Our Ref: AW/168/19/HH
Your Ref:

Town & Country Planning Act 1990 (as amended)
Town & Country Planning (Development Management Procedure) (England) Order 2015
Application for Planning Permission for Works or Extension to a Dwelling

Development Car port to front of garage
Location 1 Aldwick Place Aldwick

BLOCK PLAN
1:500 @ A3

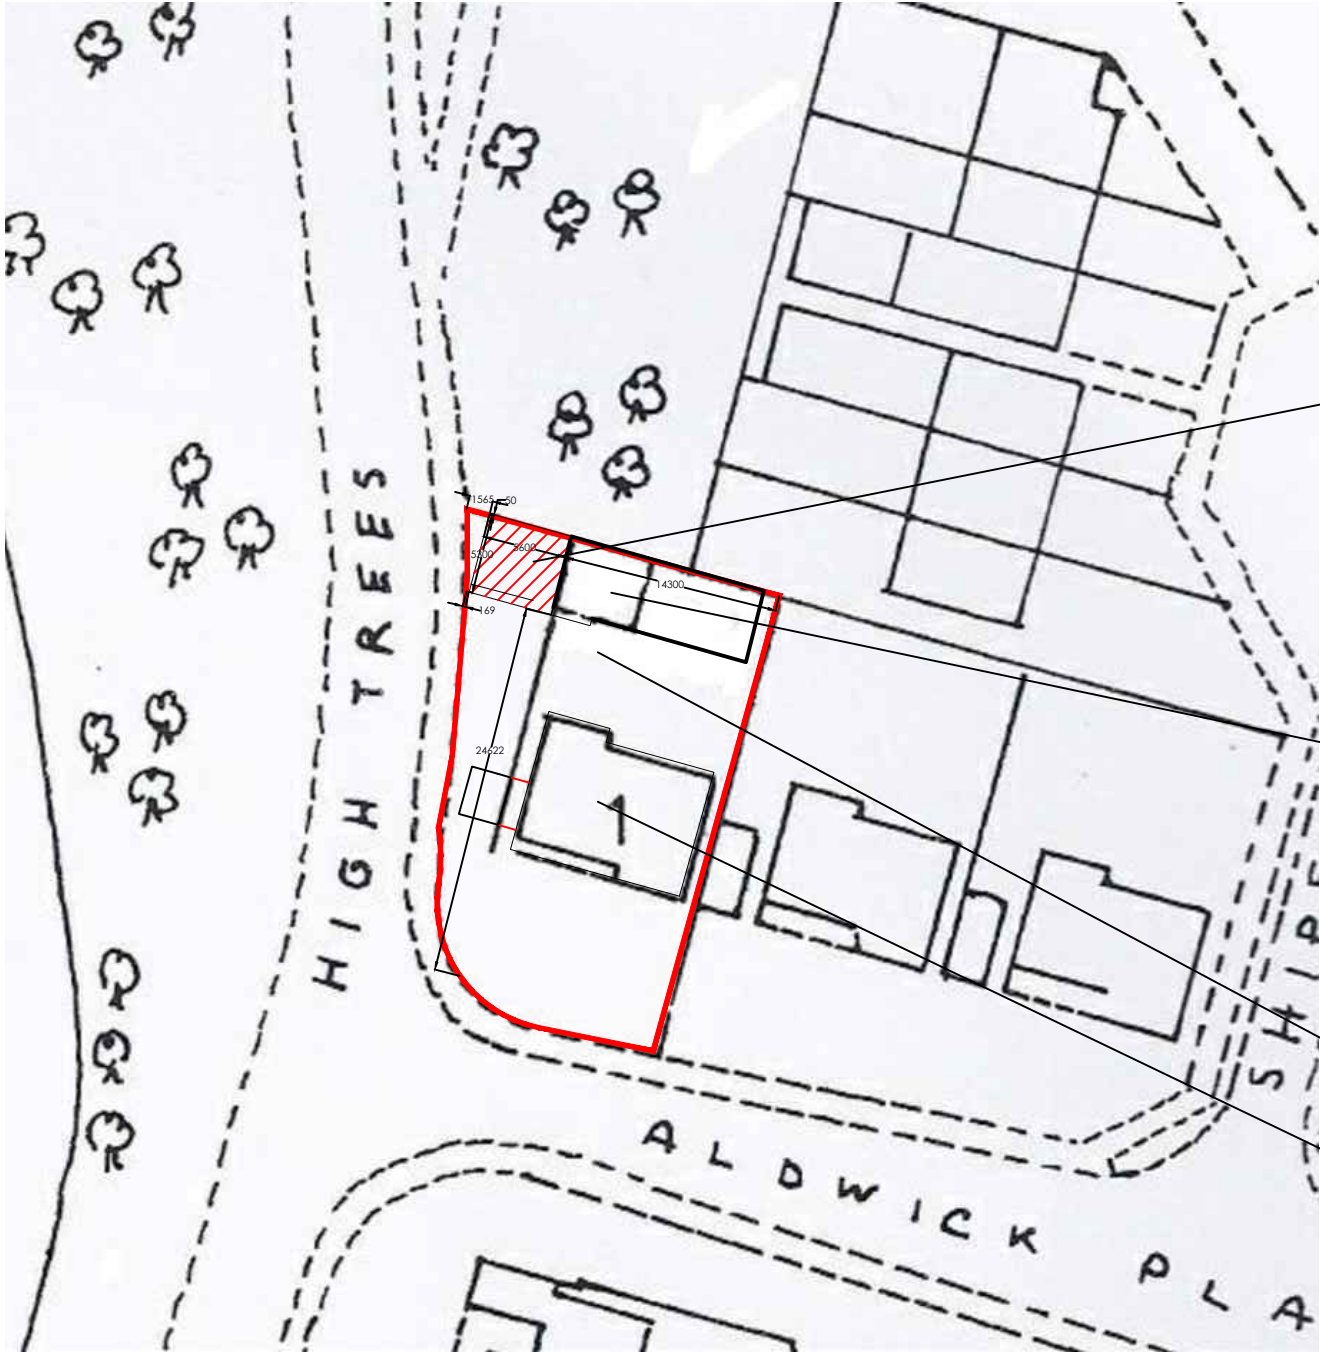
Block Plan

Please submit 1 electronic or 3 paper copies of a block/site plan which includes all dimensions from the proposed car port to all site boundaries.
